PLANNING CONSULTATION RESPONSE

Application No	2026/0088
Proposal	Retrospective application for the construction of a new vehicular access track and associated security fencing to support the operation and maintenance of a new Sewage Pumping Station (SPS)
Address	Land to the North of Balk Farm Court, Birdwell, Barnsley
Date of Consultation Reply	15/07/2026
Consultee	Highway Drainage

TITLE: **INDICATIVE SURFACE WATER DRAINAGE LAYOUT**

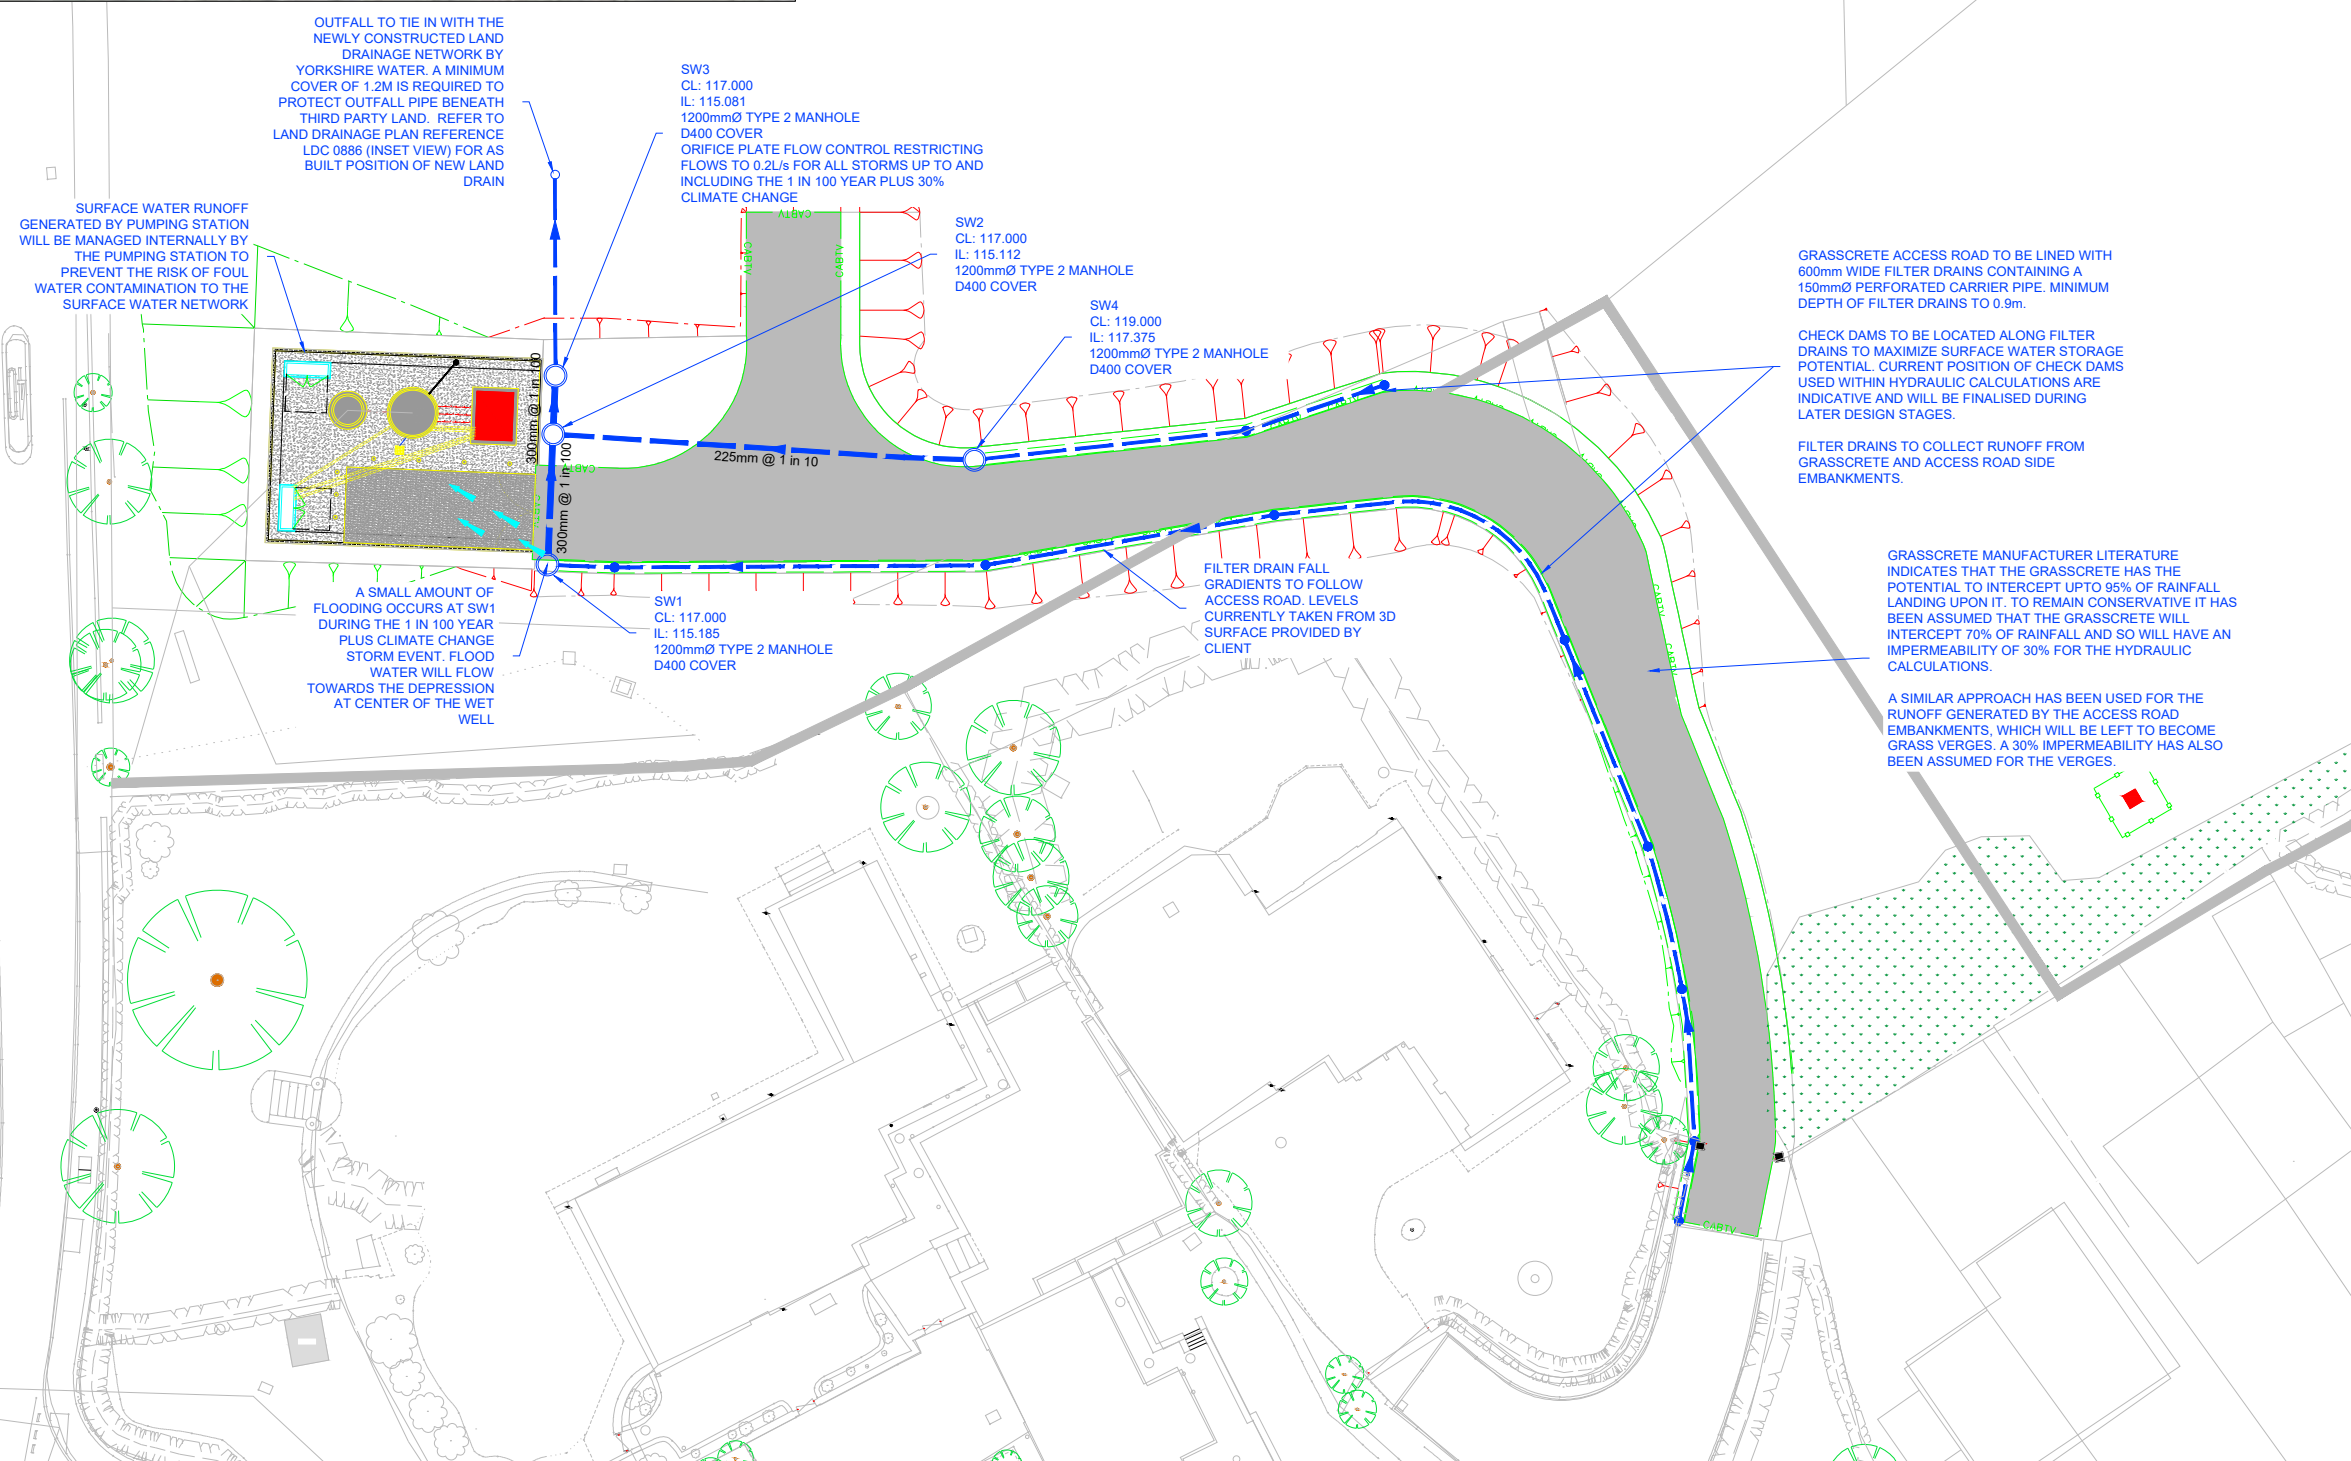
H 28 All surface water run - off shall be collected and disposed of within the site and shall not be allowed to discharge onto the public highway, in the interest of road safety
